W08/107

**Environmental Assessment Exhibition – Major Project 08\_0046  
D'Albora Marina, Western Side of Spit Road, The Spit, Mosman**

I refer to the Department's letter dated 8 March 2011 seeking NSW Maritime's comment on the Environmental Assessment (EA) for the above project.

client	Ardent Leisure Pty Ltd	address	The Spit, Mosman	job no	DMS	drawing no	DA02
project	d'Albora Marina Refurbishment	site	Floor Plan L1	drawn	CC	issue	Q
				checked	mmk		
				scale	1:200		
				@	A1

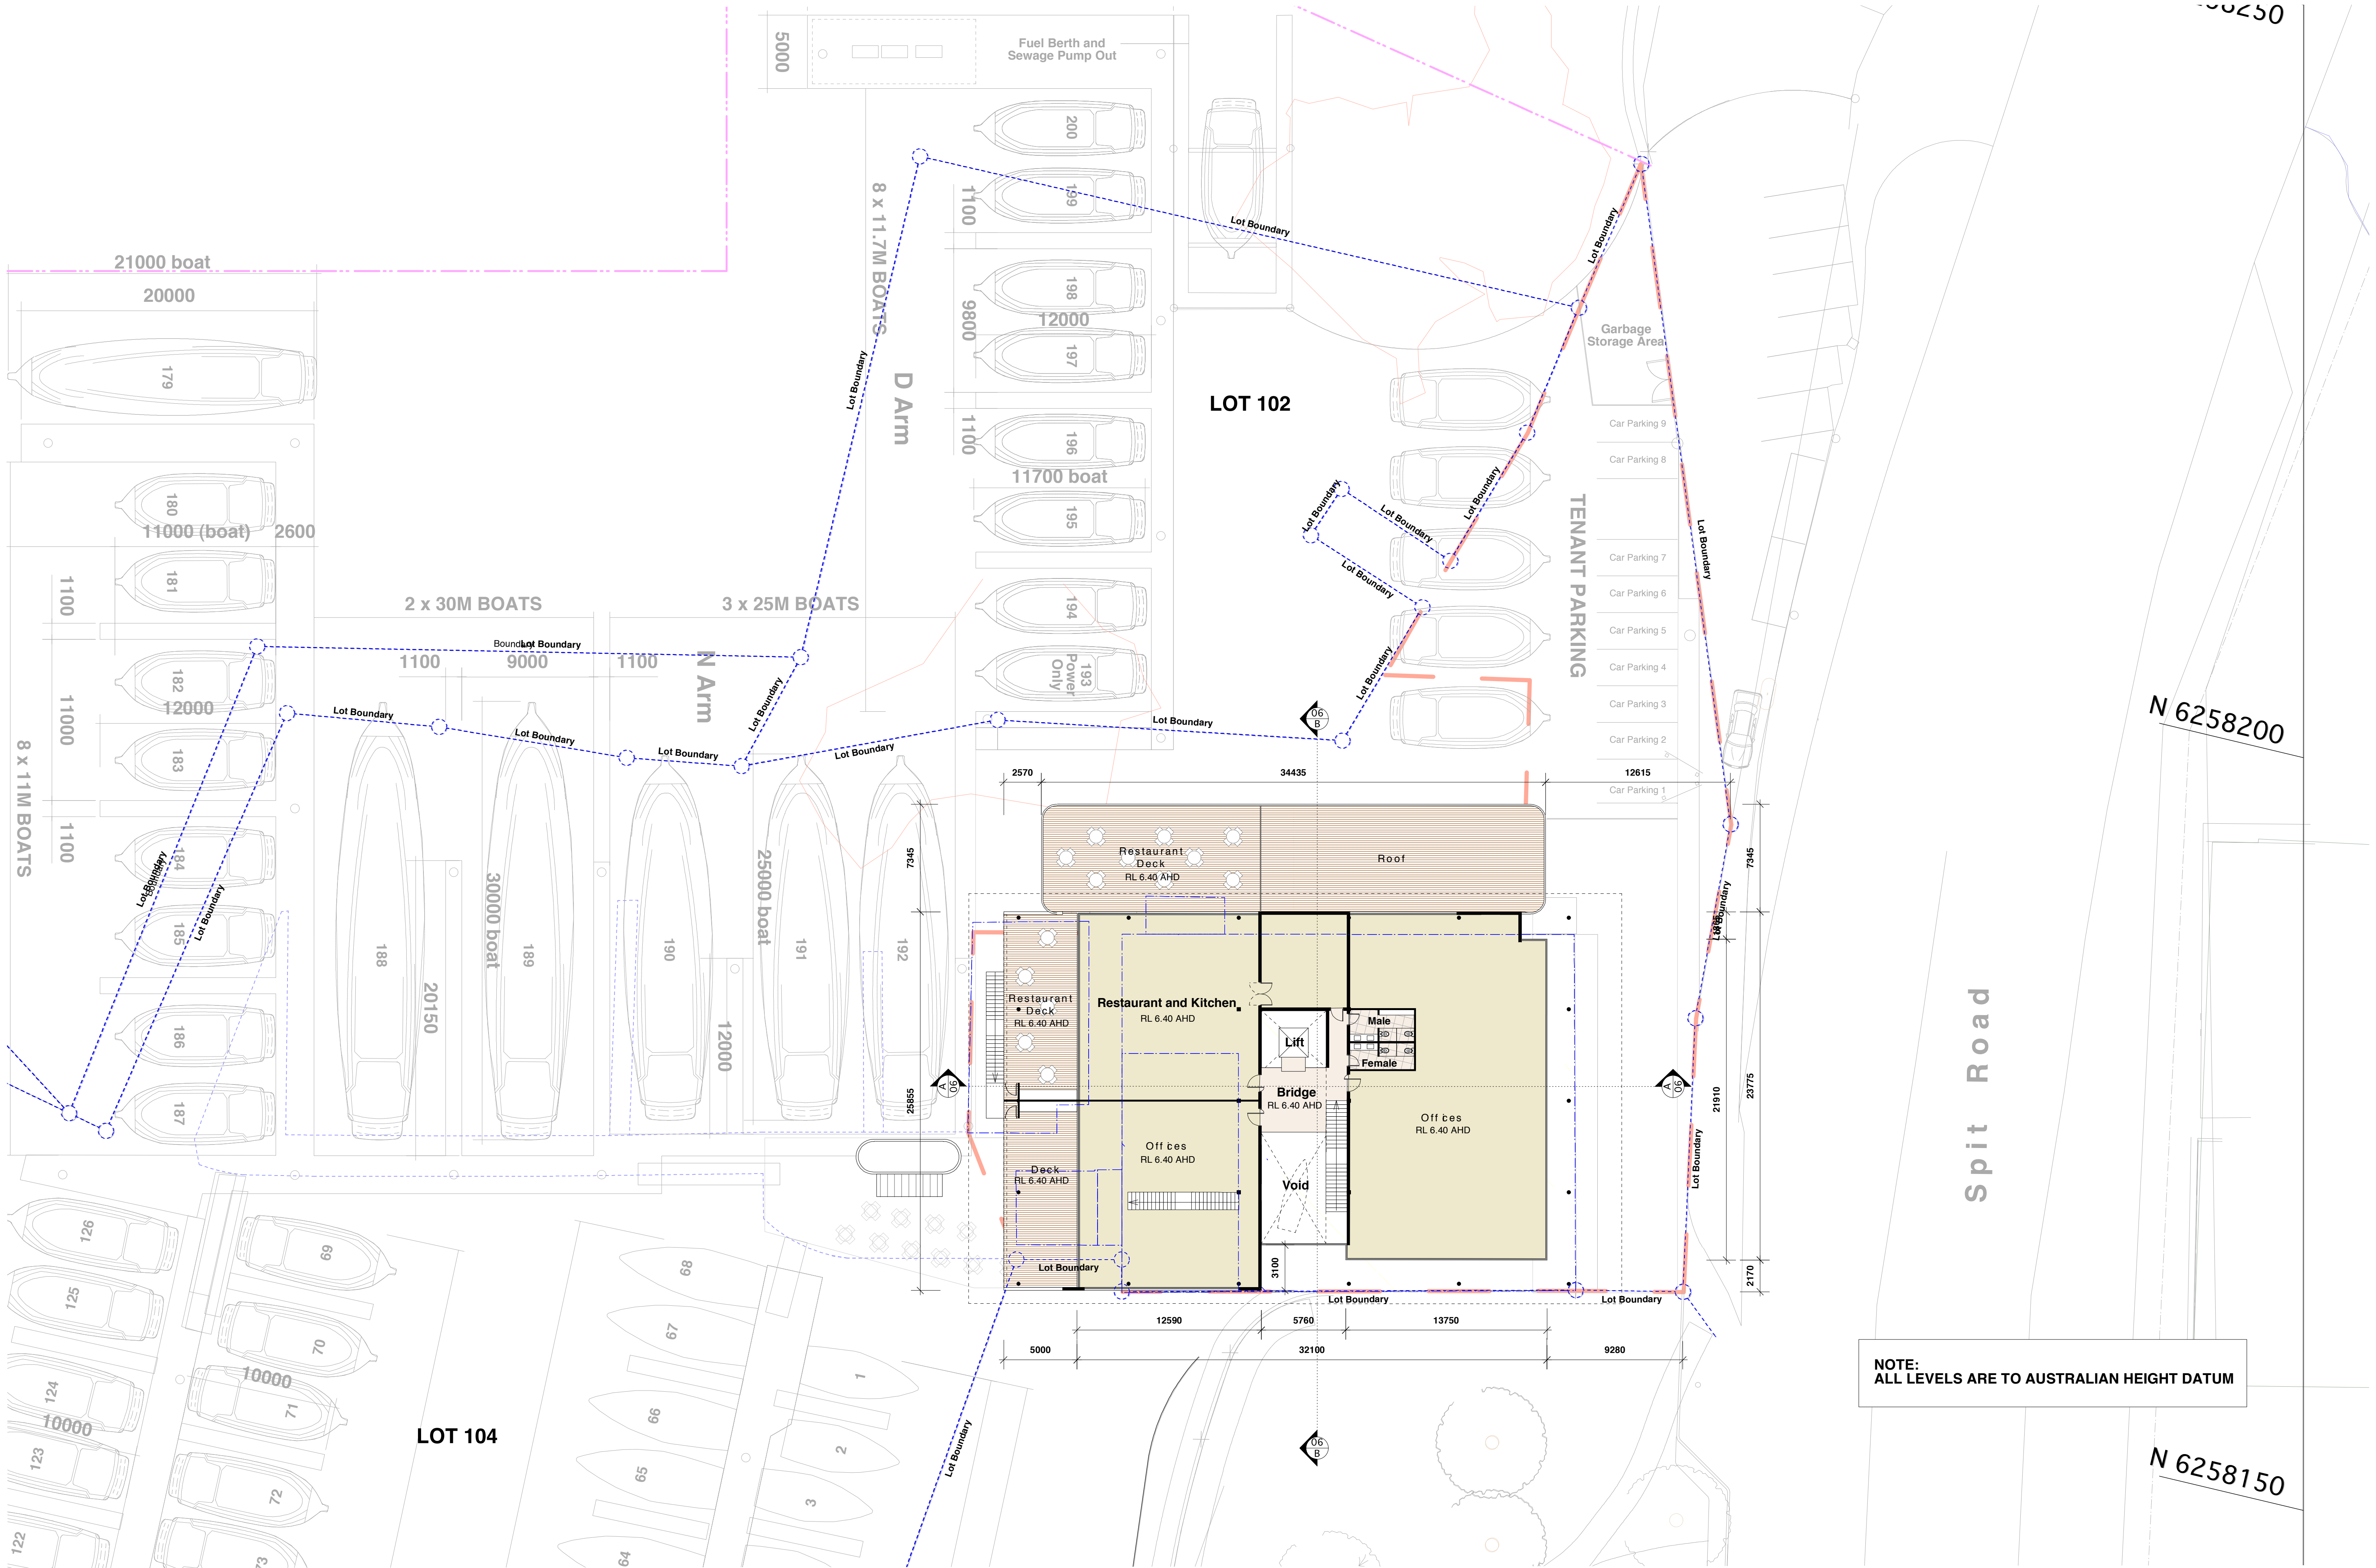
4. There appears to be insufficient depth of water in berths 193 and 194 according to AS 3962 *Guidelines for design of marinas*. Also, Drawing DA01 rev Q shows a 12m power boat in berth 193, but GBA based their assessment on an 8m power boat in berth 193. While the depths do not fully comply with the code, the amount of dredging required is relatively insignificant.

7. There appears to be insufficient fairway width at the entrance to Arm C inner and Arm B outer. The east-west arm at the southern end of Arm B seems to extend a little too far on drawing DA01 Rev Q. A fairway width of 16.5m is required by AS 3962 but it appears there is only 15m on DA01 Rev Q.

10. Drawing No. DA01 Rev Q shows a proposed lease line and the consent authority may want to clarify whether the proponent is seeking development consent for the lease (subdivision) or whether the proponent is proposing to separately seek development consent for that lease.

8. Berths 1 to 35 and berth 193 should be conditioned for 8m **power boats only** in any approval.
